Consultation Response from KC, Ecology Unit		
2020/93563 81, Common End Lane, Lepton, Huddersfield, HD8 0AF		
Discharge conditions 4, 5, 6, 7 on previous permission 2020/91092 for demolition of existing dwelling (no 81 Common End Lane) to be replaced with a new detached dwelling		
Date Responded: 07/12/2020	Responding Officer: Amy Reddick	Responding Ref:

Conditions related to Ecology

Ecological Design Strategy – 2nd November 2020

Figure 2: Proposed location of two Habitat bat boxes (southern elevation)

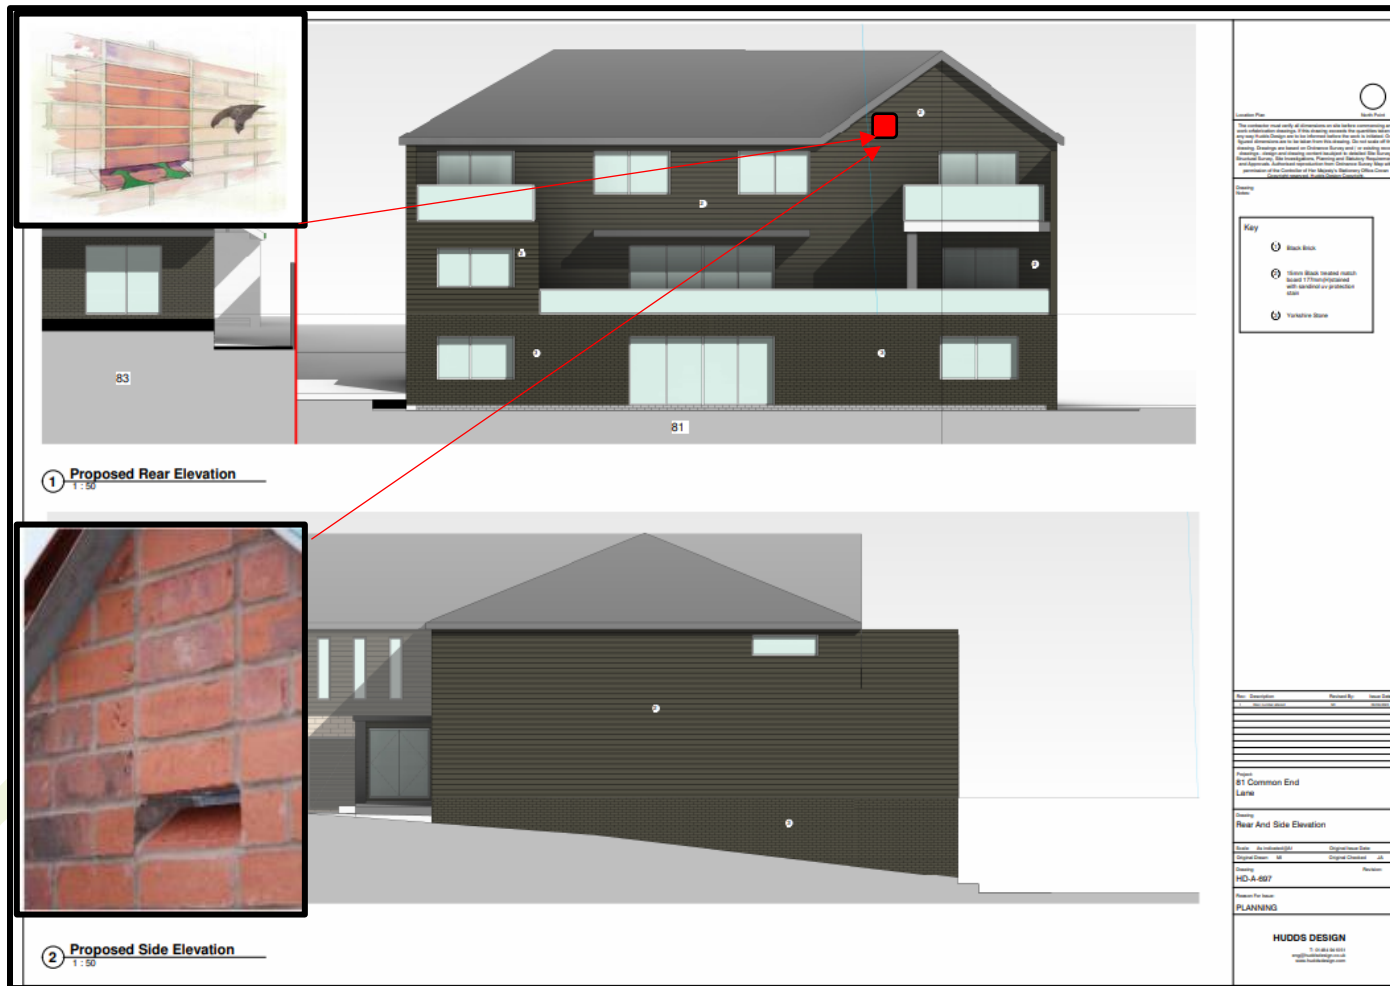
The submitted Ecological Design Strategy (EDS) includes prescriptions for integral faunal boxes and native planting on the site as well as a schedule of when these will be installed within the construction work schedule. Therefore, provided all work is carried out in accordance with the ecological measures set out within the EDS, I support the discharge of condition 4.
